Construction Drawings for Meridian Rd./Bent Grass Meadows Dr. Intersection Improvements

Bent Grass Metro District, County of El Paso, State of Colorado

Conditions (part 2) -- Per letter dated 9/22/2020, Developer and Developer's engineer agree to evaluate the revisions below and provide revisions as acceptable to the County Engineer.

SIGNAGE AND STRIPING PLAN

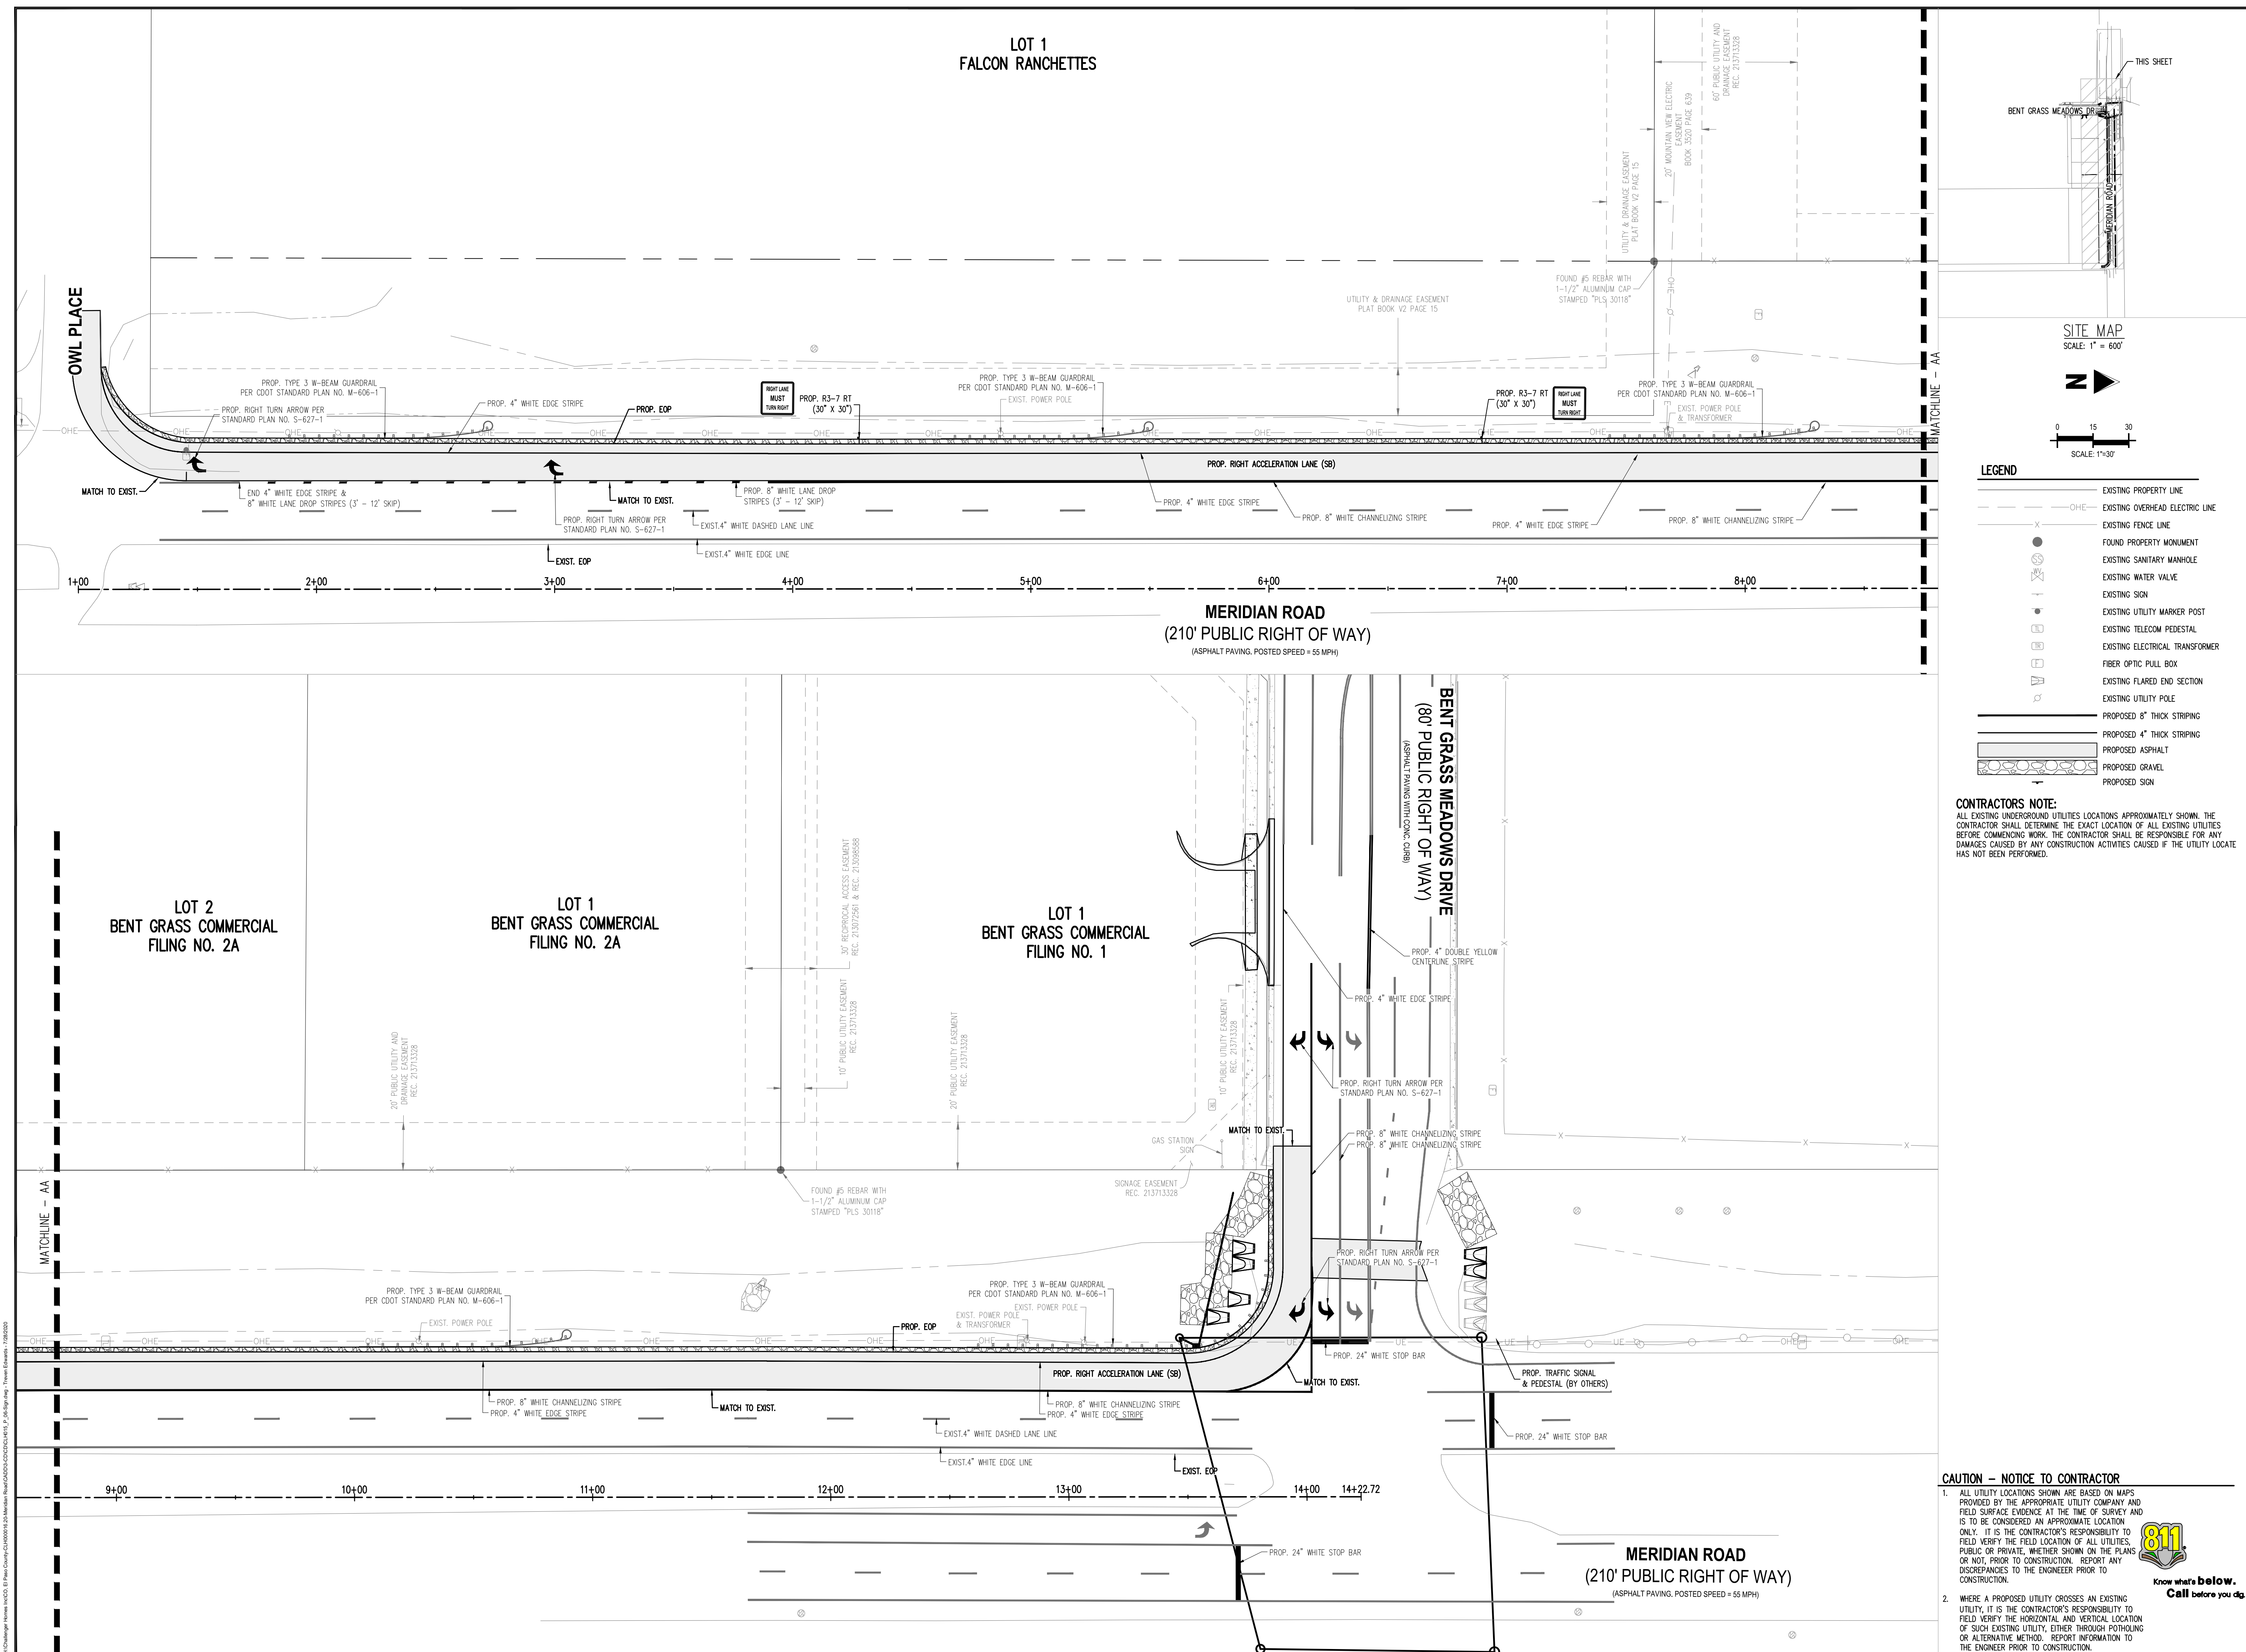
- b. A channelizing island is recommended at the southwest corner of the intersection. This would provide benefits for the eastbound right turn movement and possibly a better location for the signal pole. Truck tracking and proper drainage will need to be verified. If design time constraints are an issue and the island is recommended, revisions to the plans can be submitted when available.

- g. Add two R3-SL signs for the eastbound left turns, next to the signals.
- h. Add a R3-SR sign for the eastbound right turn lane.
- i. Recommended that "4" be removed.
